**CROSLAND CORNERS SHOPPING CENTER, U.S. 521  
 CHARLOTTE, NORTH CAROLINA  
 EXHIBIT "A"  
 TECHNICAL DATA SHEET**

**CHARLOTTE-MECKLENBURG  
 PLANNING COMMISSION  
 INTER-OFFICE COMMUNICATION**

SUBJECT: Administrative Approval for Petition No. 98-55(c), Crosland Retail.

**SUBJECT:** Administrative Approval for Petition No. 98-55(c), Crosland Retail and 2002-16, Crosland Commercial.

CROSLAND CORNERS SHOPPING CENTER, U.S. 521
CHARLOTTE, NORTH CAROLINA
EXHIBIT "A"
TECHNICAL DATA SHEET

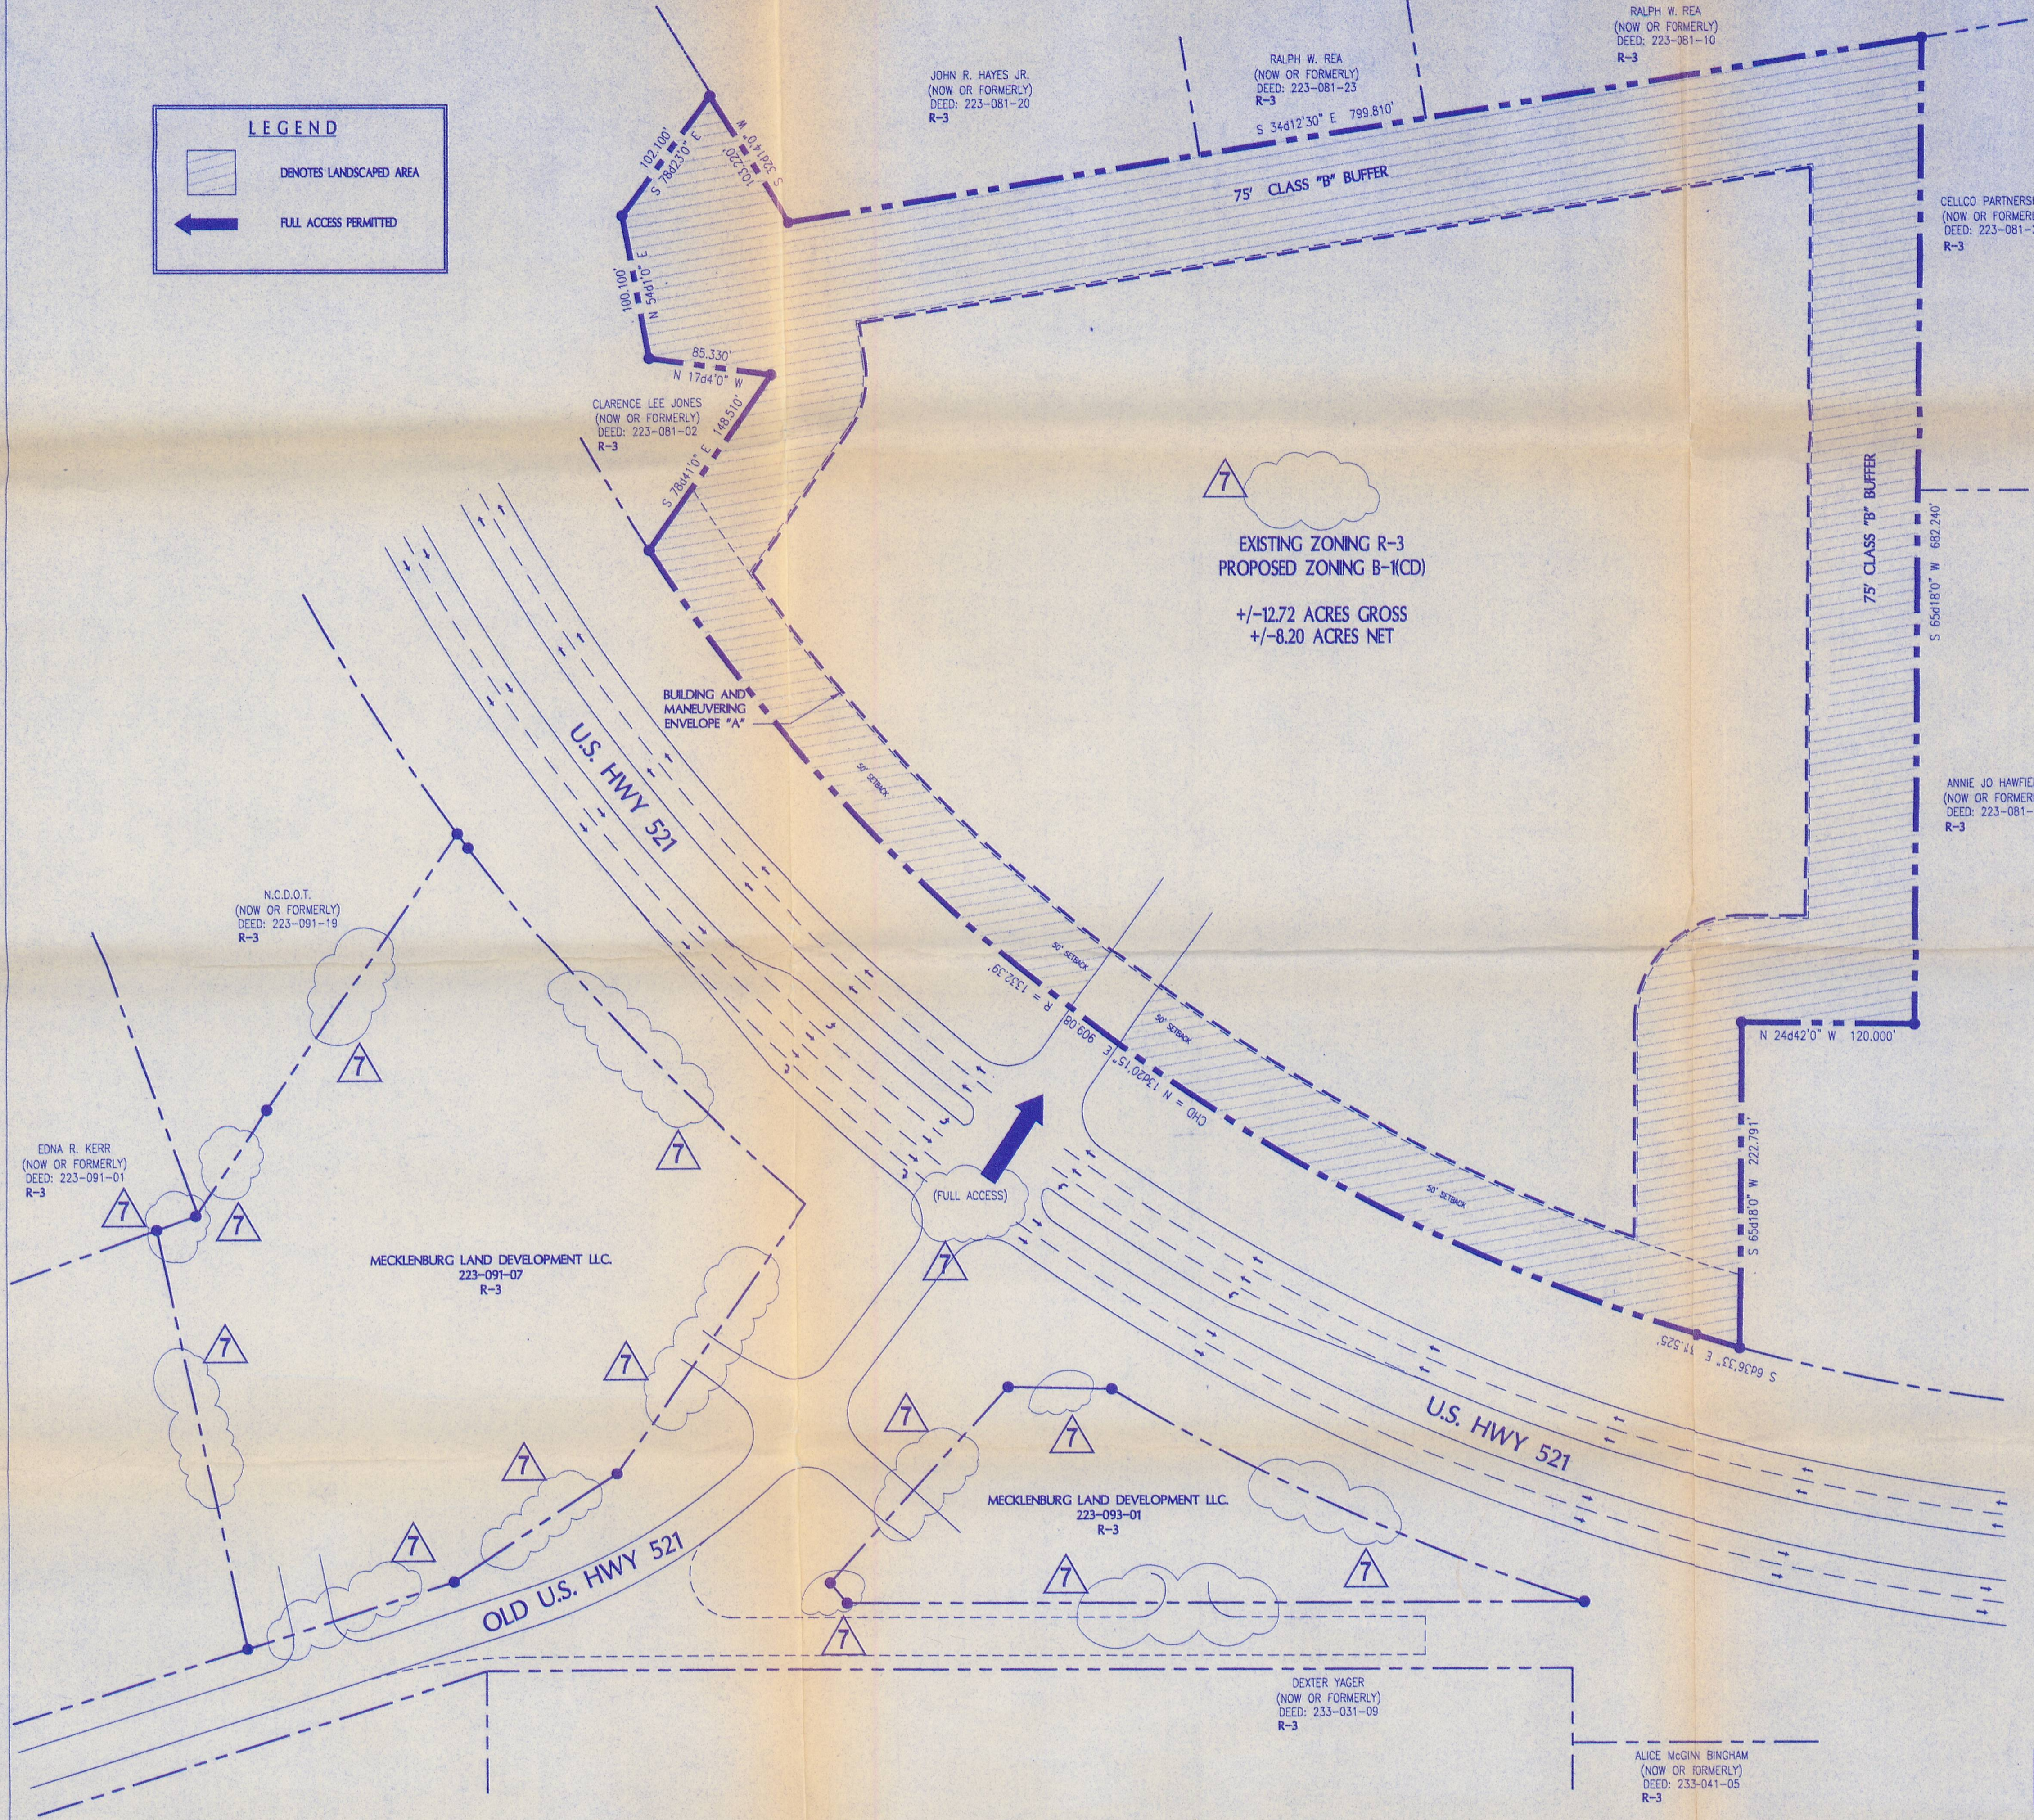
Attached is a revised plan for the above petition. The plan has been revised to increase the allowable height on the grocery store architectural element to 42-feet. This increased height only applies to the grocery store. Since this change is minor, I am administratively approving this revised plan. Please use this revised plan when evaluating requests for building permits and certificates of occupancy.

Project: CROSLAND CORNERS SHOPPING CENTER, U.S. 521
CHARLOTTE, NORTH CAROLINA
Sheet Title: EXHIBIT "B" SCHEMATIC SITE PLAN

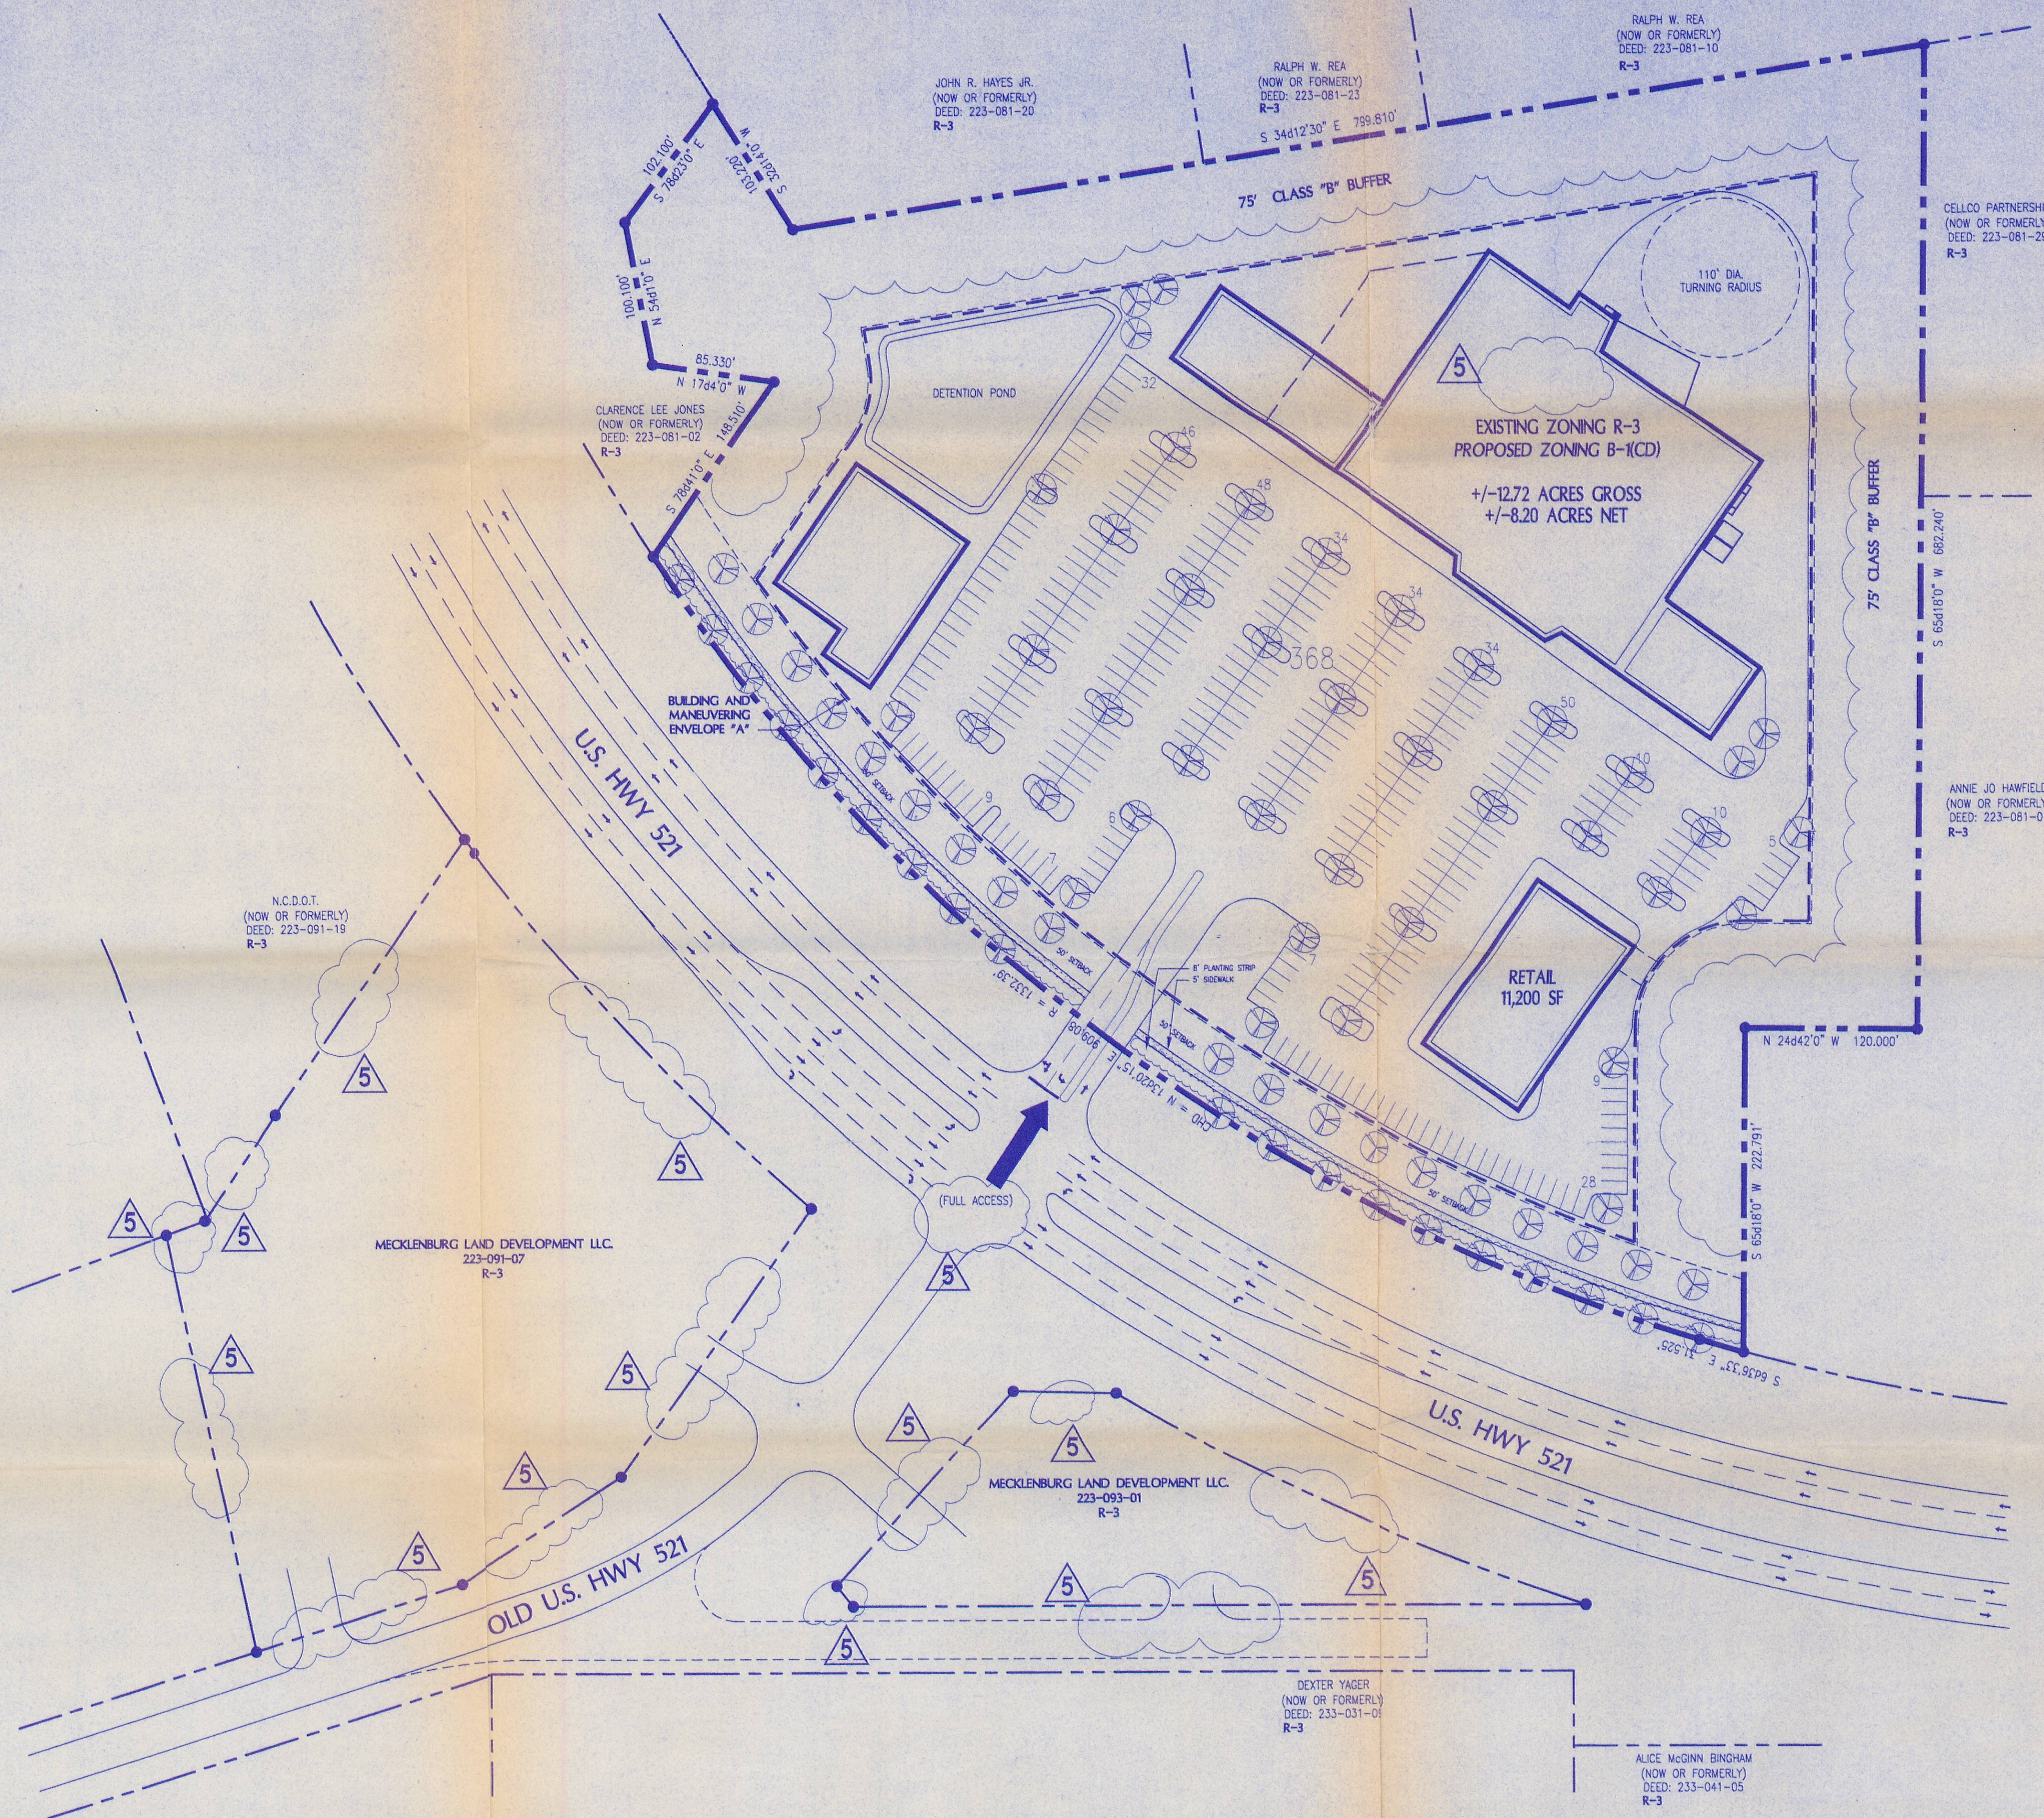
Attached are revised plans for the above petitions. Petition 98-55(c) has been revised to allow the 75 buffer to be constructed and reduced in the area shown per modifications allowed under section 12.302, increase the allowable square footage to 88,500 by transferring 8,500 square feet from the adjoining site petition 2002-16 and to allow a modified site layout as shown on sheet C-1. Petition 2002-16 has been modified to reduce the allowable square footage by 8,500 square feet of retail space being transferred to the adjoining site petition 98-55(c) and by modifying the site layout as shown on sheet C-1. Since these changes are minor, I am administratively approving these revised plans. Please use these revised plans when evaluating requests for building permits and certificates of occupancy.
